WEST SUSSEX COUNTY COUNCIL CONSULTATION

TO:	Arun District Council FAO: Michael Eastham
FROM:	WSCC - Highways Authority
DATE:	4 May 2021
LOCATION:	Land south of Ford Lane East of North End Road Yapton BN18 0DS
SUBJECT:	Y/48/21/PL Construction of temporary vehicular access off North End Road for three years to allow safe access to the affordable units throughout the remaining period of construction within the application site following Y/82/20/RES. This site is in CIL Zones 2 & 3 (Zero Rated) as other development.
DATE OF SITE VISIT:	n/a
RECOMMENDATION:	More Information Required
S106 CONTRIBUTION TOTAL:	n/a

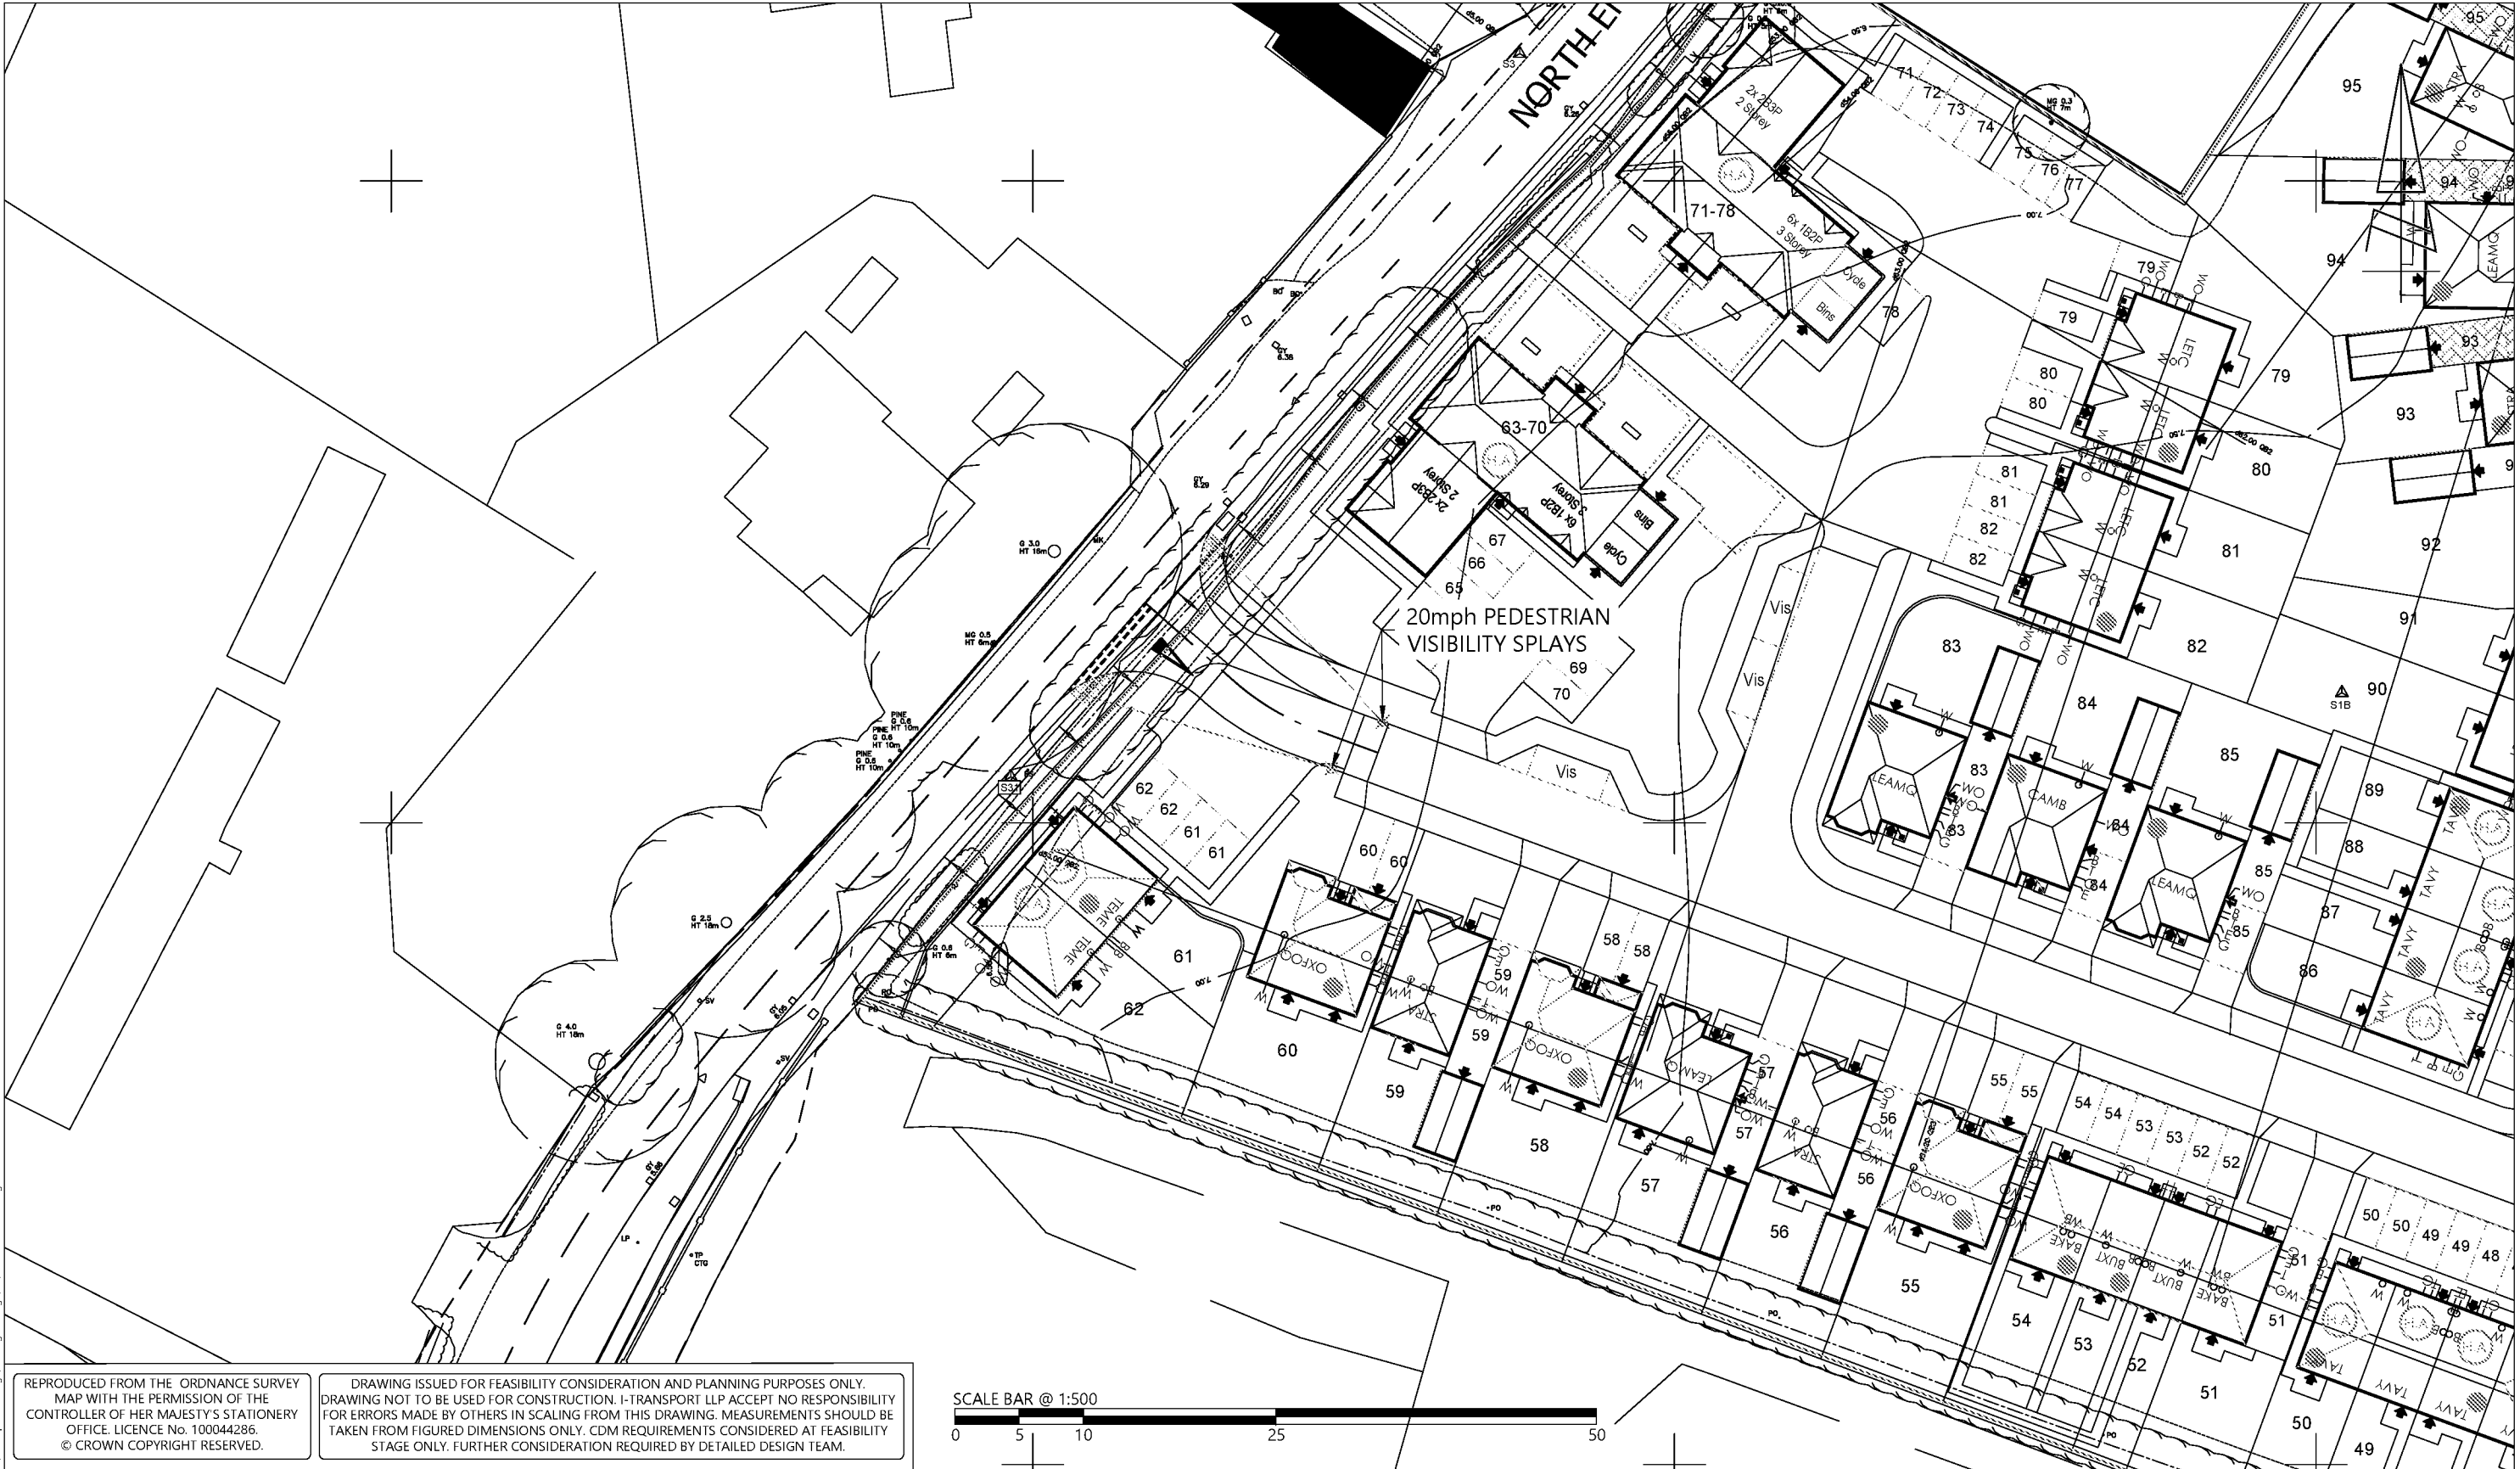
The proposal is for a temporary site access to provide access to part of the approved development approved under Y/82/20/RES on land at Ford Lane. The location of the access is on North End Road, approximately 400m south of the junction of North End Road and Ford Lane. The submitted drawing shows a formal junction-type access with bellmouth radii. A footway is shown on the northern-side of the access which would provide access to the properties it is intended to serve.

With regard to the detail of the proposal, the currently submitted drawings are not particularly clear because they have several CAD layers superimposed on them. As such, a clearer-to-read version (or versions) should be provided. Again, this matter has been discussed directly with the transport consultant and a copy (or copies) should be made available in due course. Again, these should be sent to the Highway Authority.

And finally, it should be demonstrated how any route created would not allow through-access to Ford Lane.
